Review of Response to Submissions – SSD-9522 Mod-1 – Kemps Creek Warehouse and Logistics Hub at 657 Mamre Road Kemps Creek

SECTION 4.55 (2) MODIFICATION TO PROPOSED WAREHOUSE & LOGISTICS HUB - 657-769 MAMRE ROAD - KEMPS CREEK - SSD 9522-MOD 1

**Response to Submissions – Kemps Creek Industrial Estate MOD 1 (SSD-9522) –
Modification of the site layout to accommodate changes to Lots 5-8**

Figure 9: Approved Modified Sequence 1A Mamre Road / Bakers Lane Signal layout

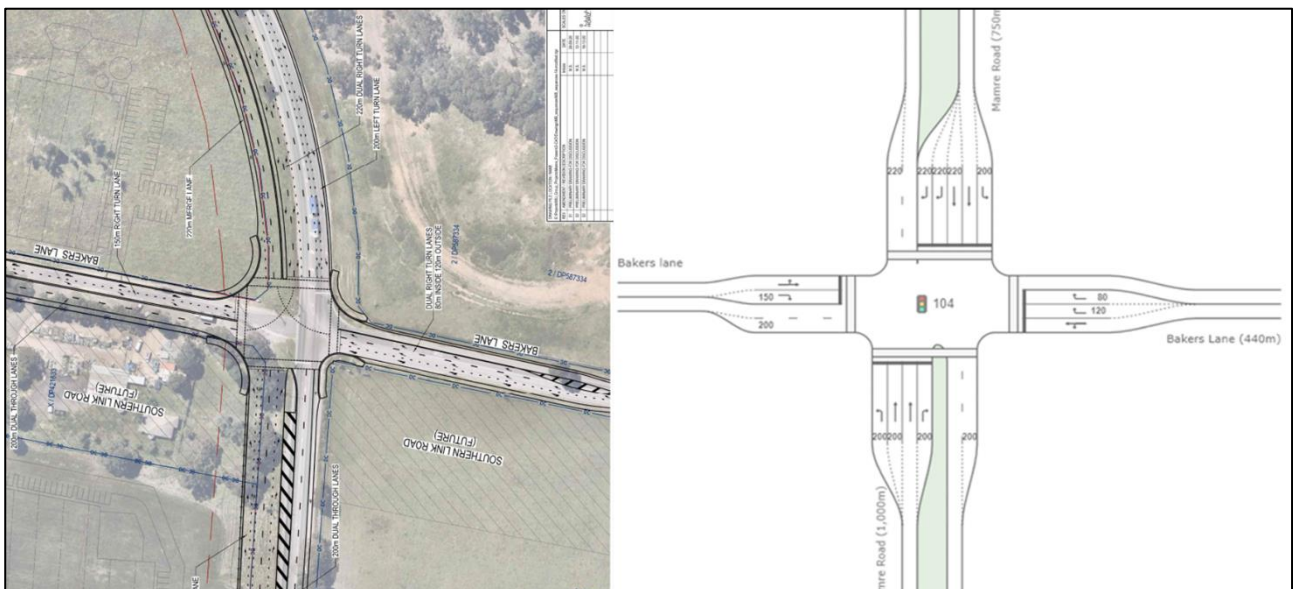
TfNSW has reviewed the Sequence 1A Modified plans and provides detailed comments in **Attachment A – Sequence 1A Modified design review**

As per ID 1 in the attached design review (Attachment A) the cross section on Mamre Road either side of the intersection (ignoring at the tie ins) does not match the cross section adopted for the section between the M4 Motorway to James Erskine Drive and James Erskine Drive to Kerrs Road. This ultimately will result in a complete rebuild of the lanes and surrounding infrastructure (ie. Footpaths etc) when the road is upgraded.

The proposed design raises constructability issues for the future upgrade and would result in major disruption to the road users for an extended period of time. TfNSW suggests that further refinement to the plans are considered to bring them in line with TfNSW ultimate Mamre Road upgrade and Southern Link Road (SLR) plans. This could be (but not limited to) in the form of constructing the northbound lanes (along this developments frontage) to the ultimate location (including underground services, footpaths, shoulders etc) to reduce the total works required for the ultimate Mamre Road upgrade and reduce the impact to the road users.

TfNSW recommends further refinement of the proposed modified plans which take into account elements of TfNSW Mamre Road ultimate upgrade design. TfNSW is supportive of attending a meeting with the applicants to discuss possible design refinements to ensure the best outcomes for road users.

Figure 2: Subdivision Plan – Stage 1

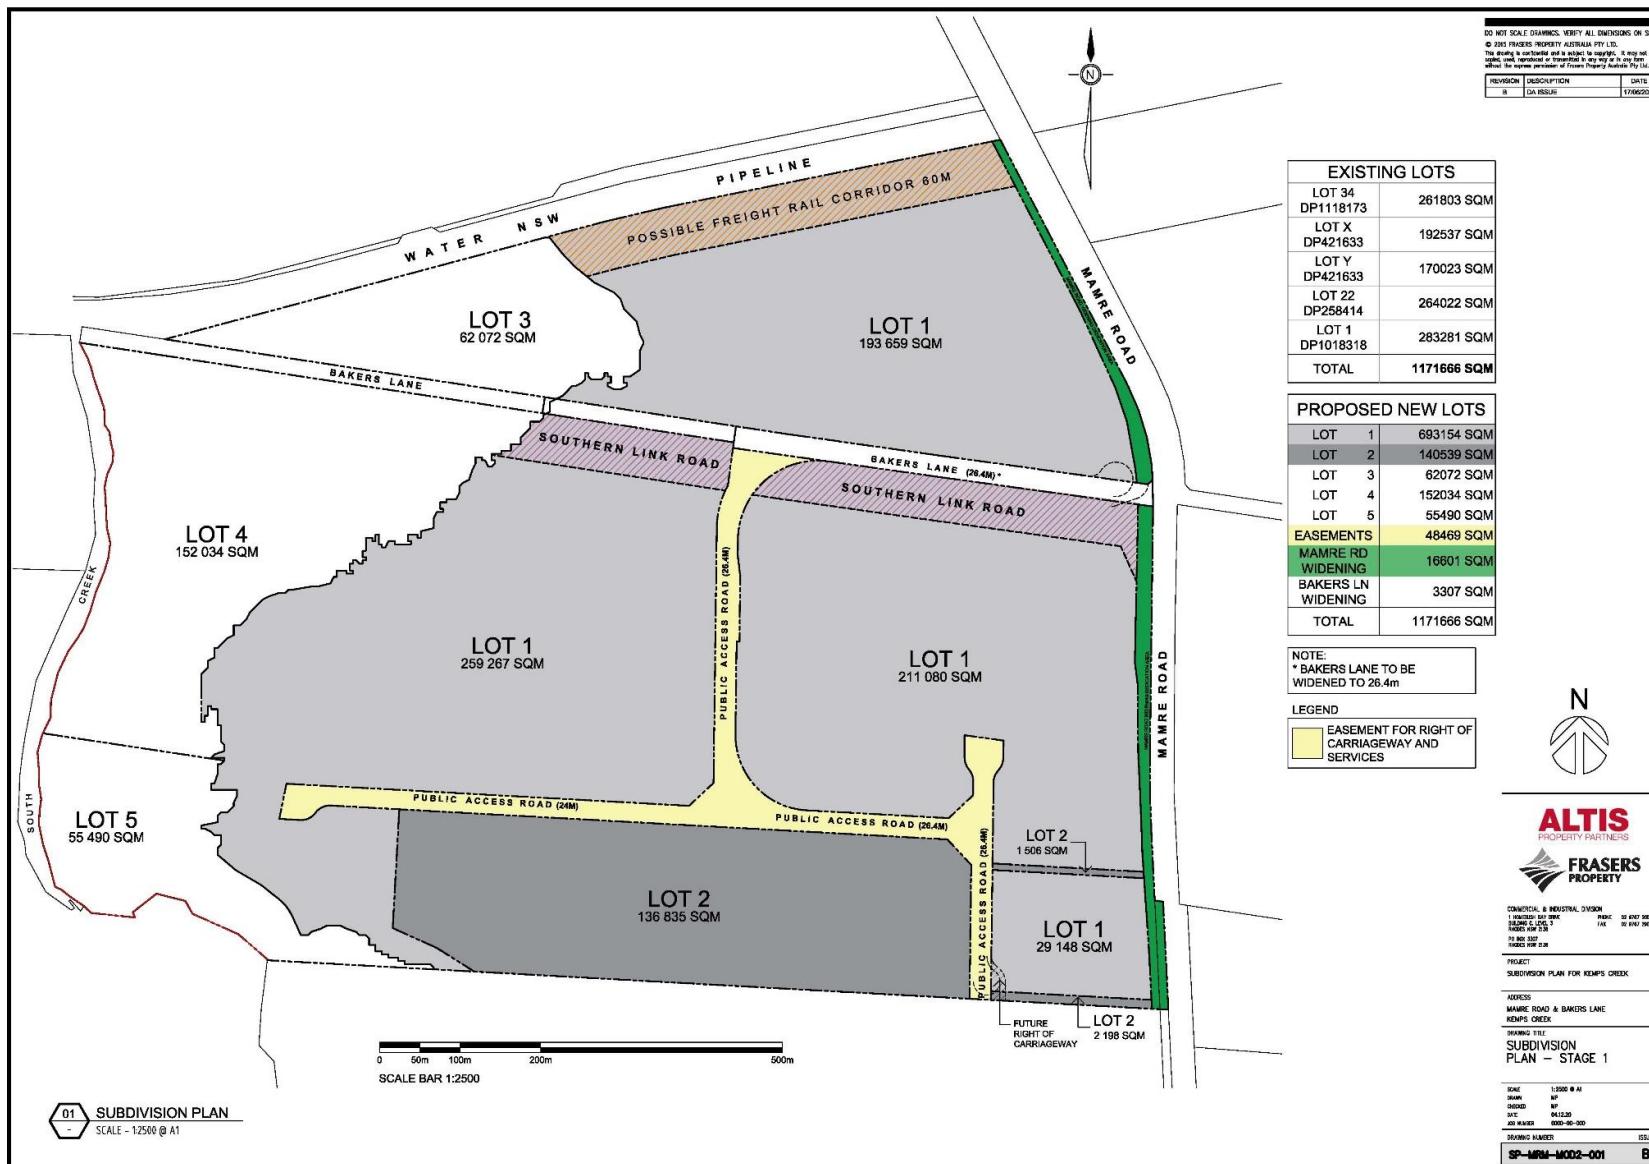
As previously stated, TfNSW is in general not supportive of any access to the NS Rd 1. However, TfNSW notes that the proposed slip lane for Lot 5 (from end of taper) at the NS Road is proposed to be 100 metres south of the future SLR signals, this is considered an acceptable distance.

The access to the slip lane pre signals is located on the departure of the bend, which is not considered an ideal location. However as Bakers Lane and the NS Rd1 are local roads, this is matter for Council to consider if the risk raised by TfNSW are satisfied.

TfNSW notes that the light vehicle access from NS Rd 1 to service Lot 5 (southwest corner) is intended to be an egress point only which will cater for emergency vehicles access to satisfy BCA requirements. Clarification is required to understand how this access will be restricted to egress only should ingress for emergency vehicles be provided. TfNSW has concerns that the egress only with the inclusion of emergency vehicle ingress raises compliance issues and could be used as an access for light vehicles. In this regard, TfNSW would not support multiple connections to the NS Rd1. It is suggested that the access points are consolidated to ensure safety and compliance.

It is therefore recommended that the access points for Lot 5 are consolidated to ensure safety and compliance. Alternatively should this be a BCA requirement, that the emergency access is gated to restrict all general light vehicle traffic.
